**KIRKLEES METROPOLITAN COUNCIL
INVESTMENT & REGENERATION SERVICE**

**DELEGATED DECISION FOR DISCHARGE OF CONDITION -
NOTIFICATION OF A CHANGE OF USE UNDER THE ABOVE
PROVISIONS**

Reference no. 2025/CL/92186/E

**Site Address Headlands, Falhouse Lane,
Whitley, Dewsbury, WF12 0NJ**

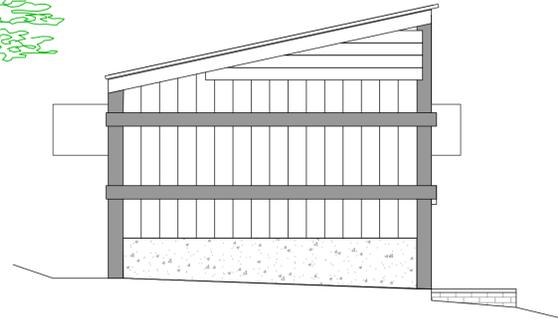
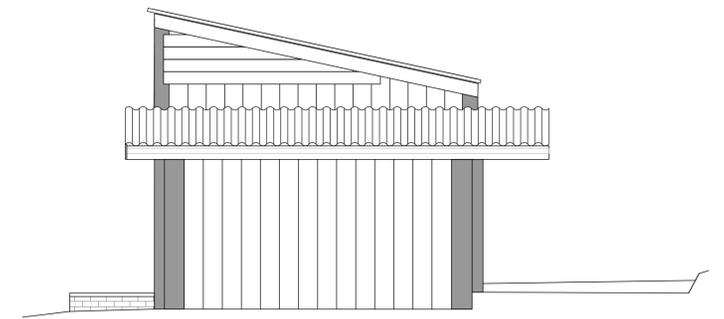
The proposal would include the entire western elevation featuring a zinc cladding, the majority of the south, north buildings external materials and the roof of the building being replaced with zinc cladding.

The submitted proposed plans state that the external walling will be the existing cladding on the existing building on the east elevation, but the majority of the external walls would be replaced with zinc cladding and the roof.

Overall, it appears from the information provided that all, or at least the vast majority, of the existing external walling and roofing material is to be replaced. The structural report indicates the existing floor slab is not level and will be covered with new flooring. While the structural capability of the existing supporting members of the building are claimed to be sound, the new building nonetheless, consists of replacing practically all of the existing wall materials and where not, additional works to cover the walling materials are proposed. Overall, very little of the existing building envelope is capable or proposed to be retained. It is therefore considered that the buildings as they currently stand, would not be capable to function as converted dwellings without the significant degree of proposed building works. In this case, the proposed works would be considered so extensive as to comprise rebuilding and therefore cannot be considered within the definition of “conversion.”
